Subject: CPHR advice – Response to Submissions - NEXTDC S5 Data Centre and Innovation Hub (SSD-63168959)

Thank you for your correspondence received 24 November 2025 seeking comments from the Conservation Programs, Heritage and Regulation (CPHR) Group regarding the Response to Submissions for the NEXTDC S5 Data Centre and Innovation Hub (SSD-63168959) at 269 Lane Cove Road, Macquarie Park.

CPHR advice – Response to Submissions - NEXTDC S5 Data Centre and Innovation Hub (SSD-63168959)

Trees Removed by Scope of Works

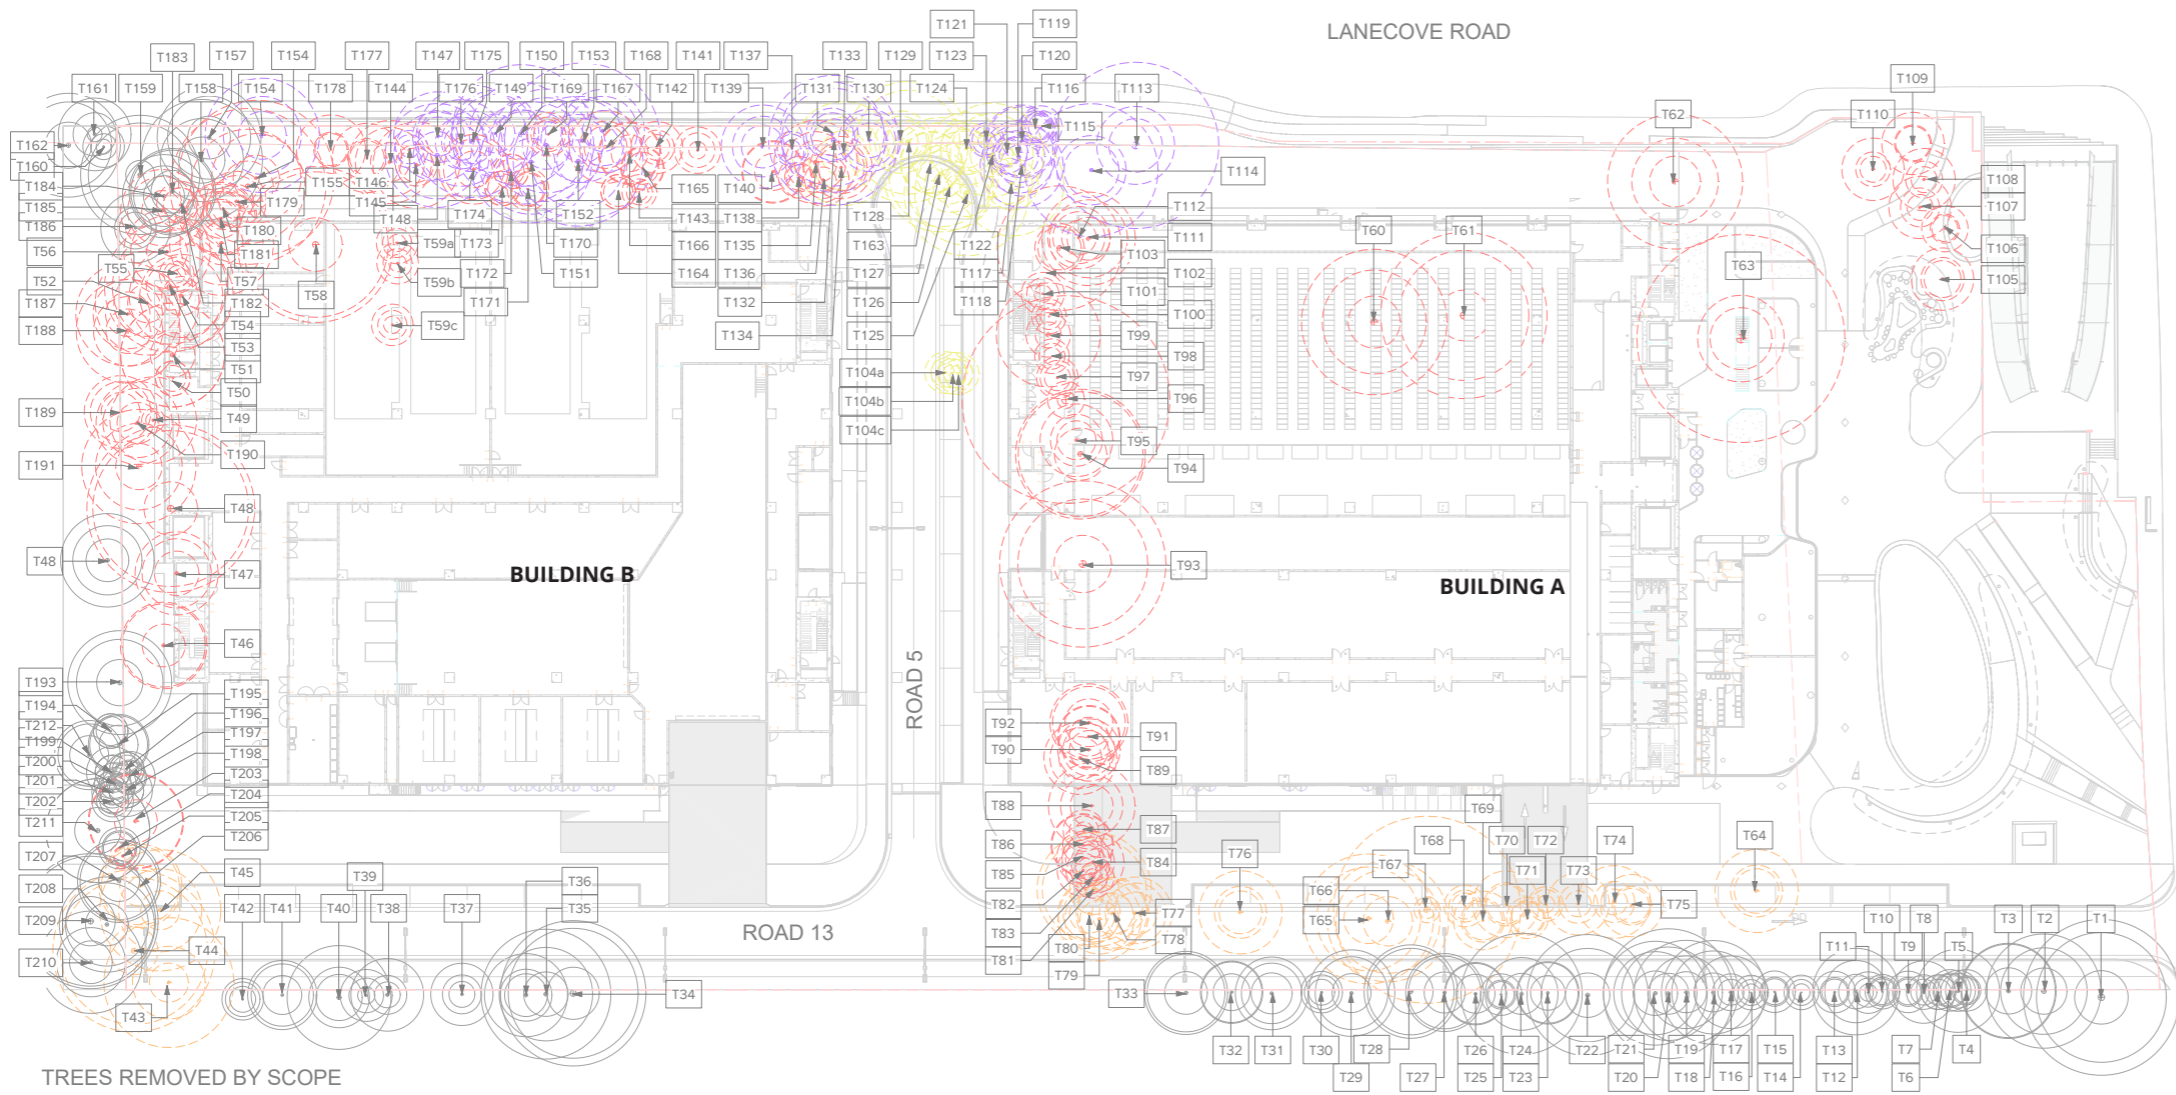
4.	Adequacy of the AIA	The AIA proposes to remove several trees located on neighbouring land along the south-western boundary. This is not supported.  Recommended action • Amend the plans in consultation with the consulting arborist to enable the viable retention of all neighbouring trees in line with AS 4970–2025. • Provide an updated AIA that demonstrates how neighbouring trees will be viably retained.
	<i>Extent and Timing</i>	Pre-determination

5.	Adequacy of tree retention	Consideration is to be given to relocate the elevated footpath away from trees that form part of the threatened ecological community (TEC) to increase tree retention. 
----	----------------------------	--

Recommended action • Amend the plans in consultation with the consulting arborist to enable additional TEC trees to be retained viably in line with AS 4970–2025. • Provide an updated AIA that demonstrates how additional TEC trees will be viably retained. • If the relocation of the boardwalk is not feasible, provide a justification.
	<i>Extent and Timing</i>	Pre-determination
